June 30, 2014  
*Revised July 29, 2014*

**Subject: The Forefront at Thompson's Point – Amended Phase 1A Plan**  
**Applicant: Forefront Partners, I LP**  
**Phase 1A Activity – Renovation and Occupying Existing Brick North Building**  
**Resubmission of Application Based on Staff Recommendations**

Additionally, our office has received and reviewed your review comments dated 7/16/14 and offer our responses to these comments. For ease of reference we have repeated each comment in *italics* with our response following. Any new materials referenced below have been incorporated into the resubmitted application.

DRAWN: OED	DATE: JUNE 2014
DESIGNED: BEK	SCALE: 1" = 40'
CHECKED: SRB	JOB NO. 2982.05
FILE NAME: 2982.05-BN FIRE TRUCK ROUTE	
SHEET	C-9.0

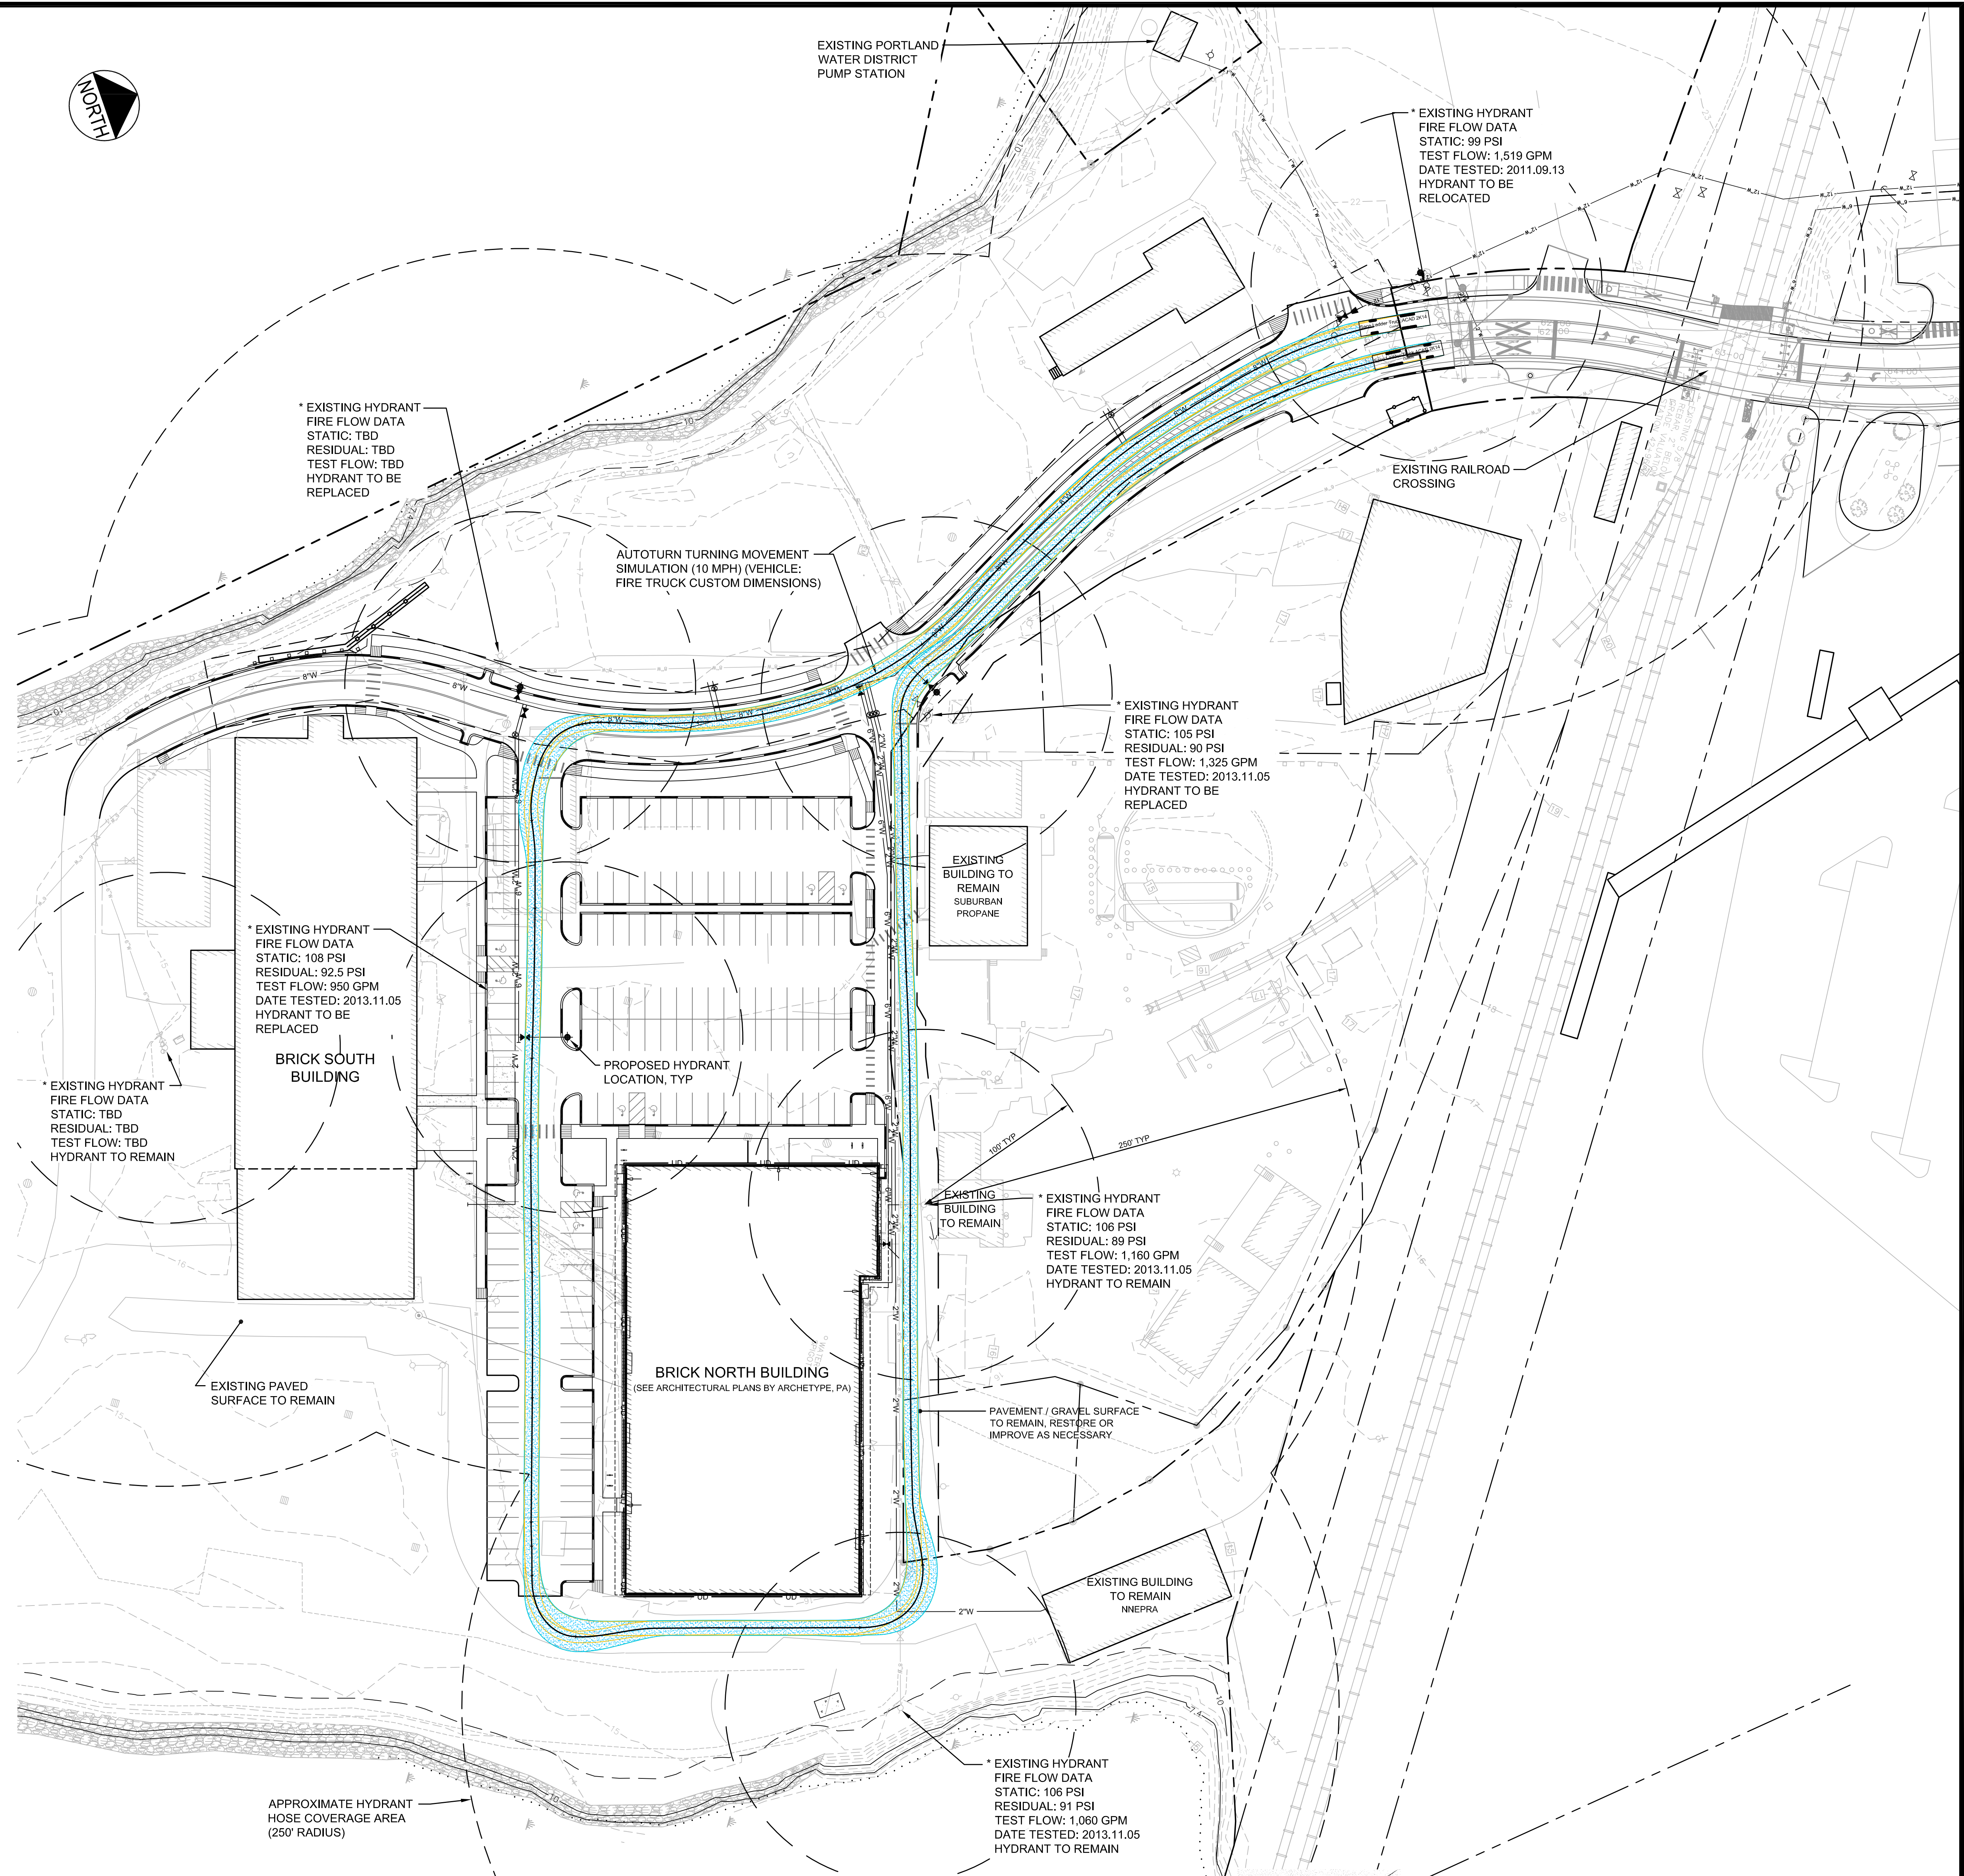
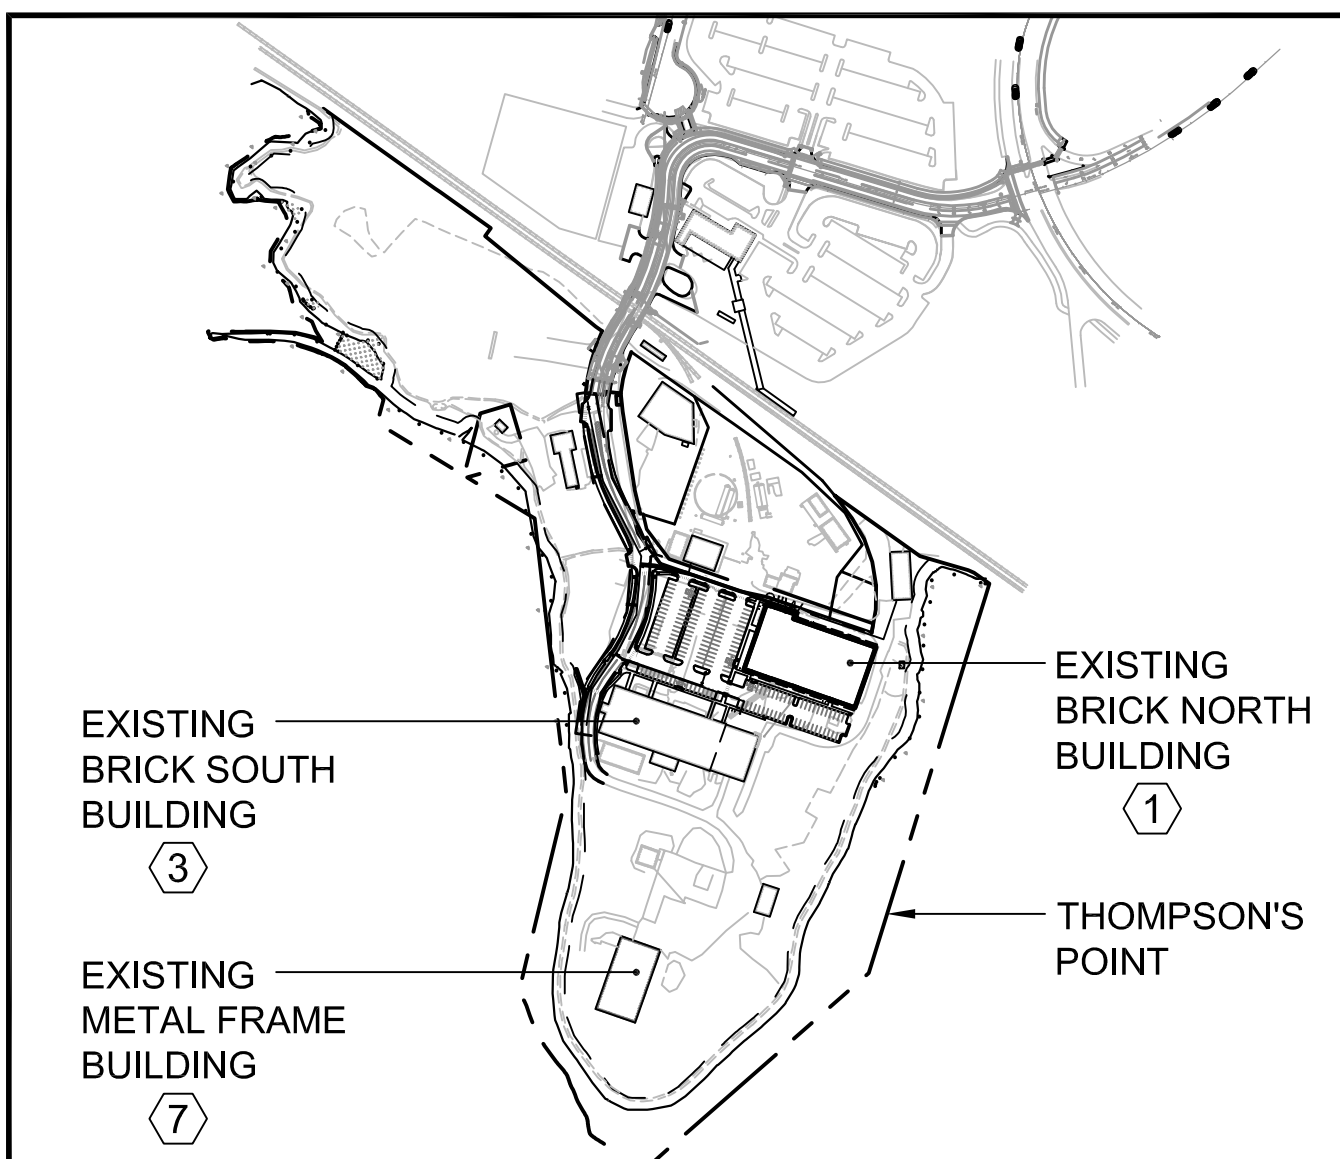
*Item 21. References a Life Safety Memorandum from Mark Cummings of Fire Risk Management, Inc., as partial fulfillment of this section – that memorandum contains comments on the previously approved pier, and has no applicability to this application. Sheet C-9.0 references a Life Safety Plan prepared by Fire Risk Management, Inc., but the date is blank. Please clarify the response to Item 21.*

The Life Safety Memorandum dated June 4, 2014 was erroneously included in the application. The correct memo dated June 25, 2014 discusses the Phase 1A site plan and is included with this application. Sheet C-9.0 has been revised to refer to the June 25, 2014 memo and included with this application.

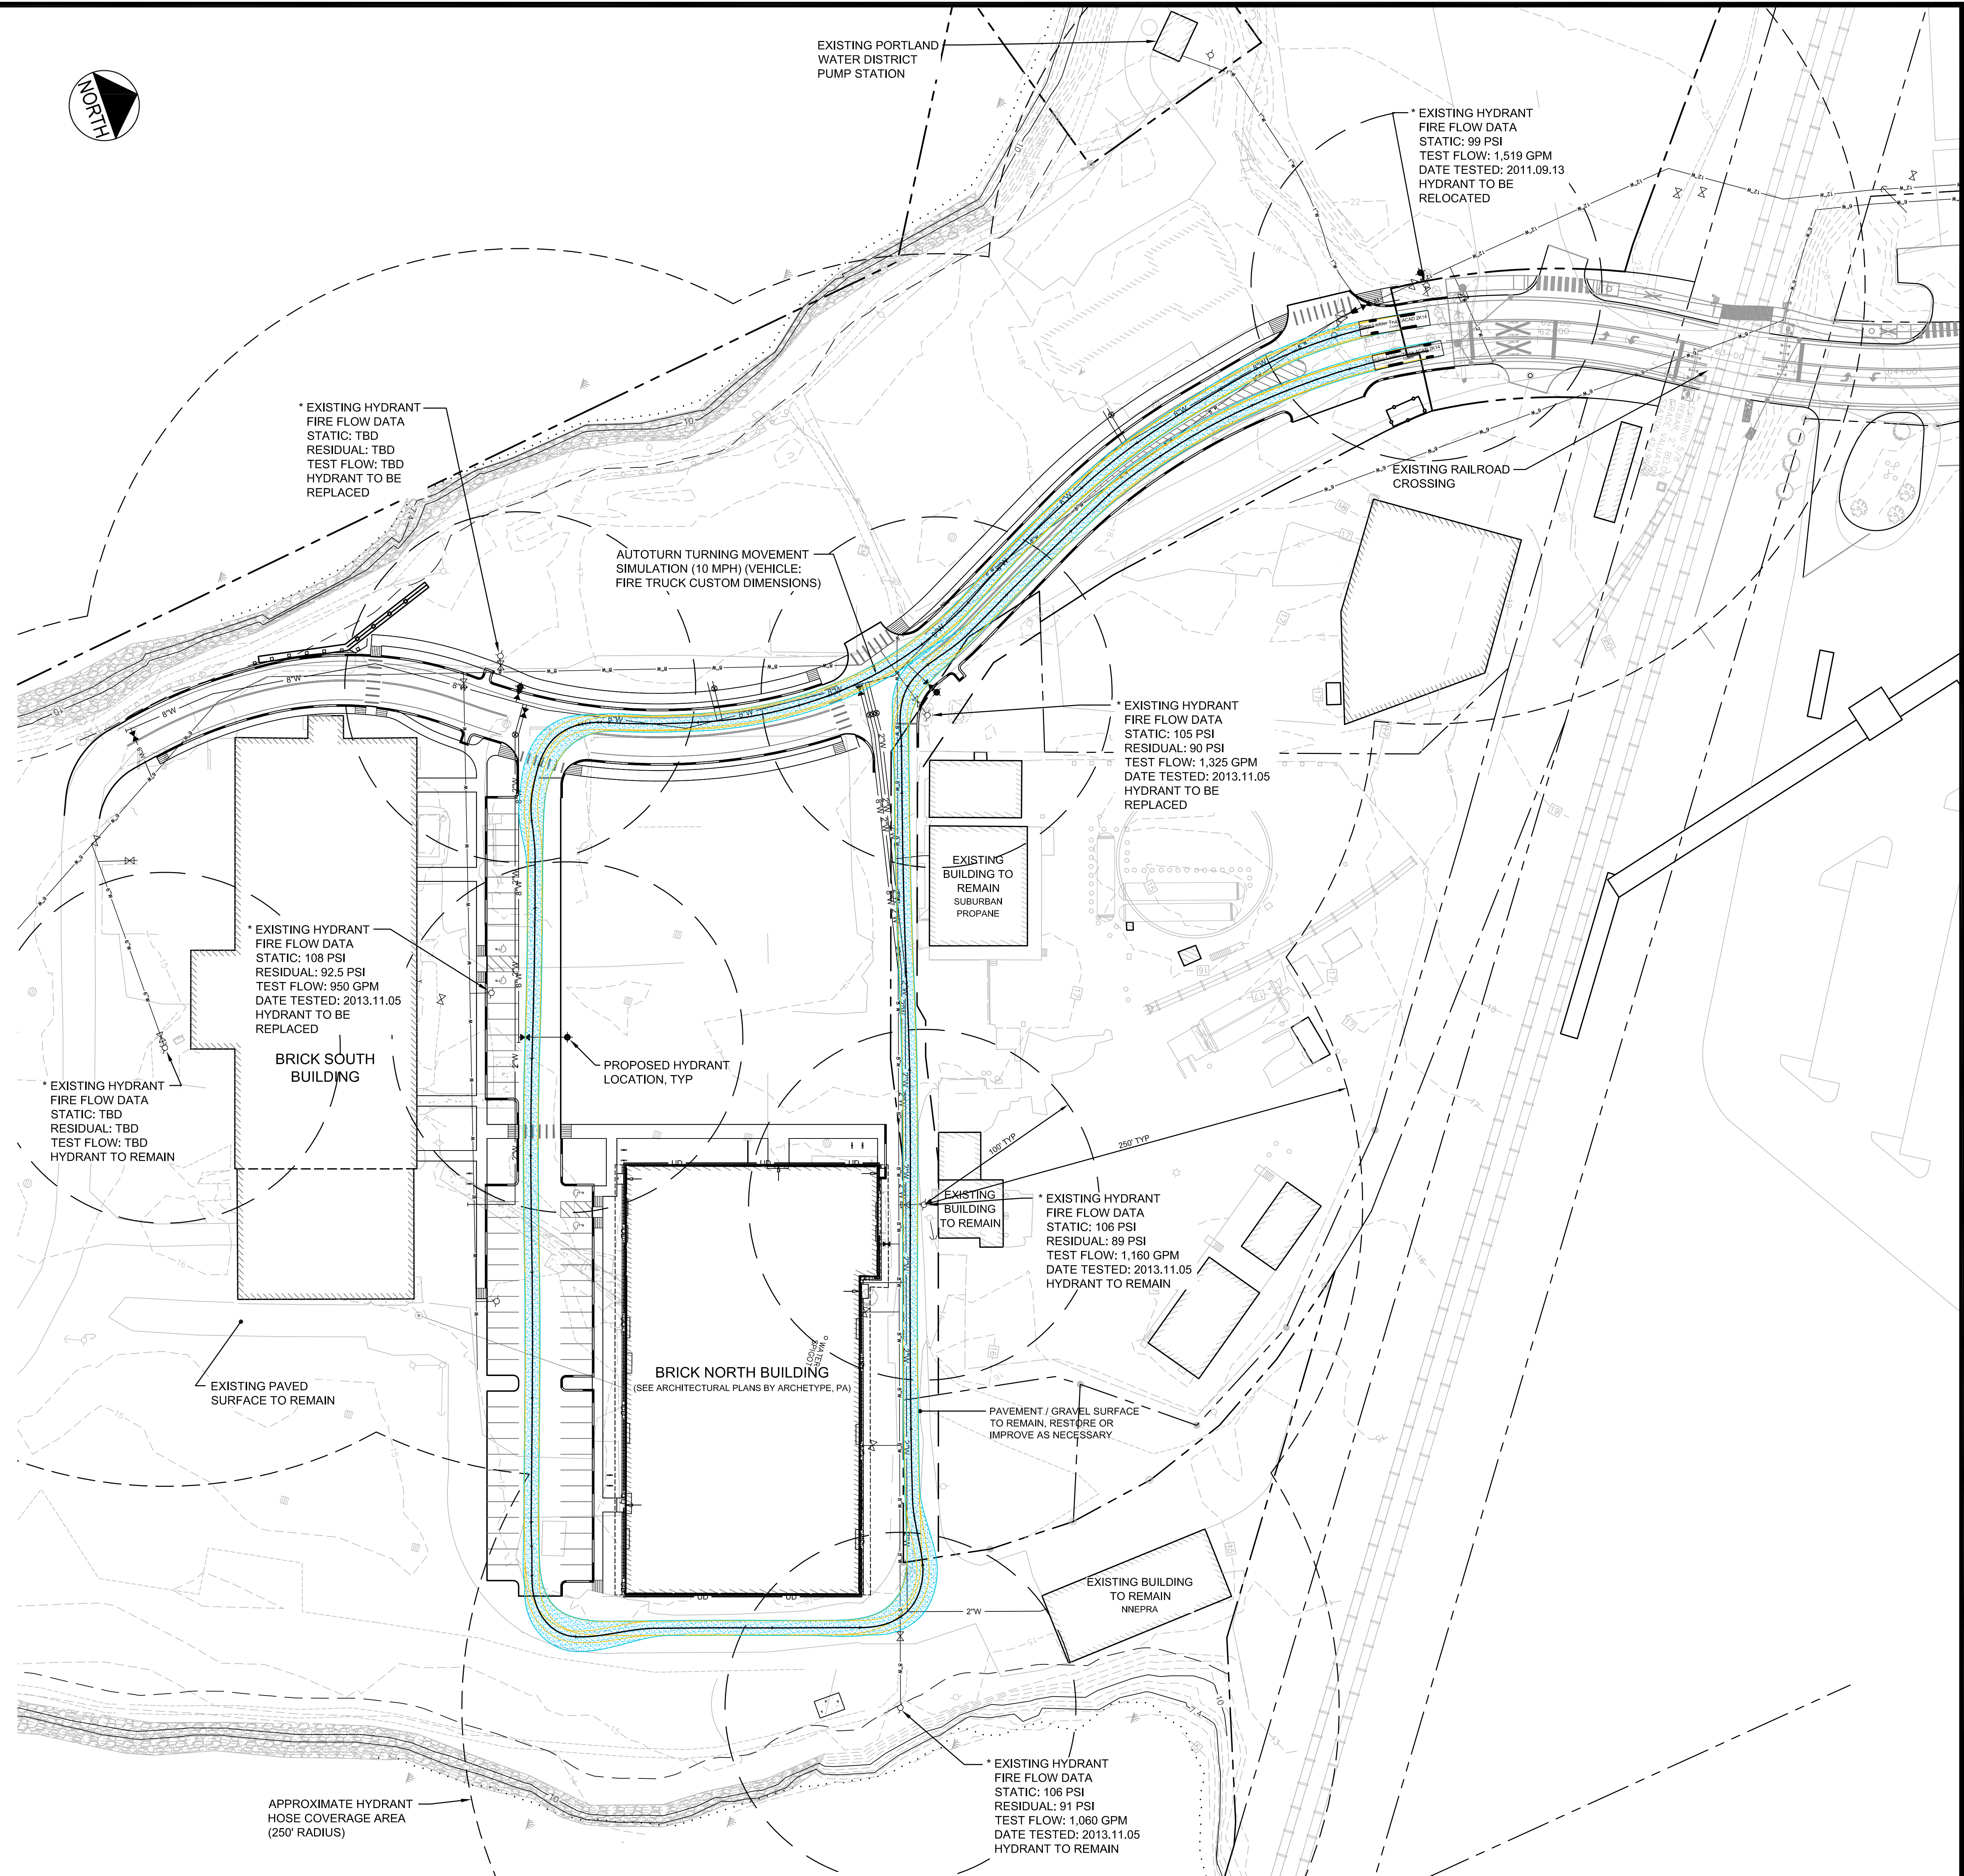
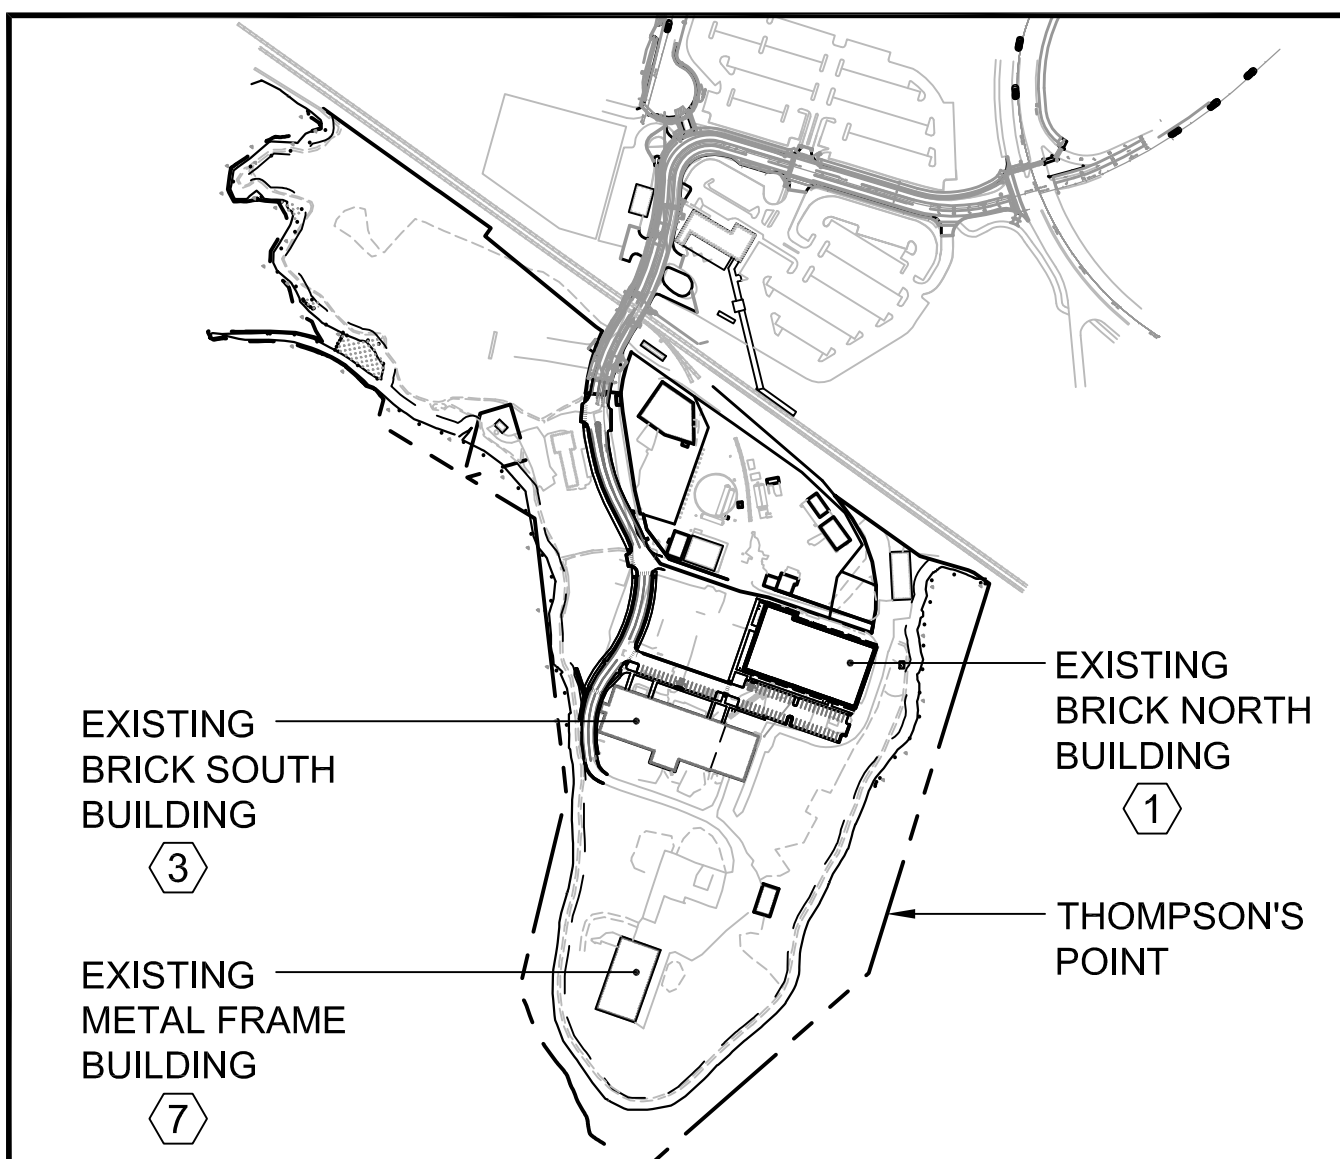
*Item 9. Is a requirement for a code summary referencing NFPA 1 and all Fire Department. The application references the June 4<sup>th</sup> Fire Risk Management, Inc. memo here, which is not applicable to this application.*

The Life Safety Memorandum dated June 4, 2014 was erroneously included in the application. The correct memo dated June 25, 2014 discusses the Phase 1A Site Plan and is included with this application. Sheet C-9.0 has been revised to refer to the June 25, 2014 memo and included with this application.
